Your ref: 3/2020/0852, 0853

Date: 11th March 2021

Planning Applications 3/2020/0852 and 0853: Reroofing of existing building and installation of one en-suite shower room.
Lovely Hall, Lovely Hall Lane, Salesbury BB1 9EQ

Planning Officer (Archaeology)
Historic Environment Team

Steps introduced to access raised part of the floor

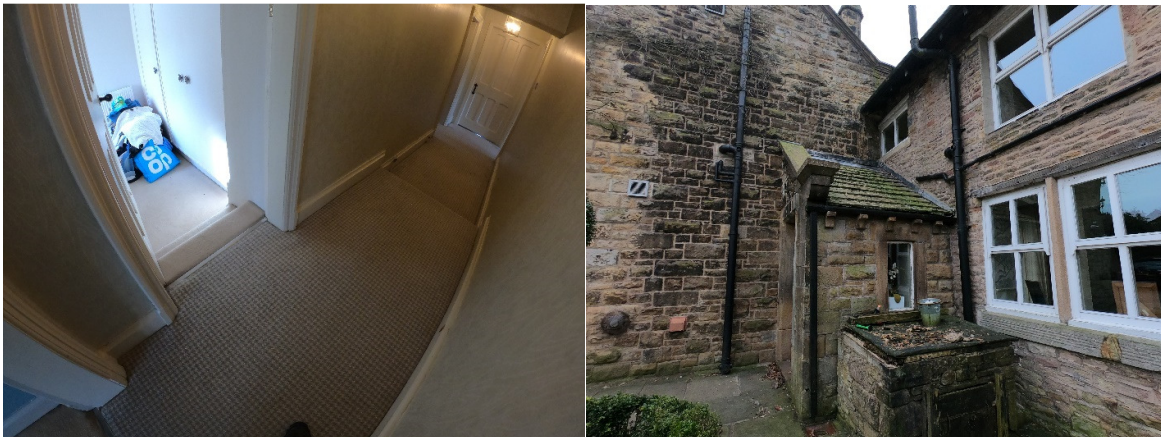
We would have no objection to the proposed removal of the plywood cupboards or the installation of new pipework into the extant floor voids.
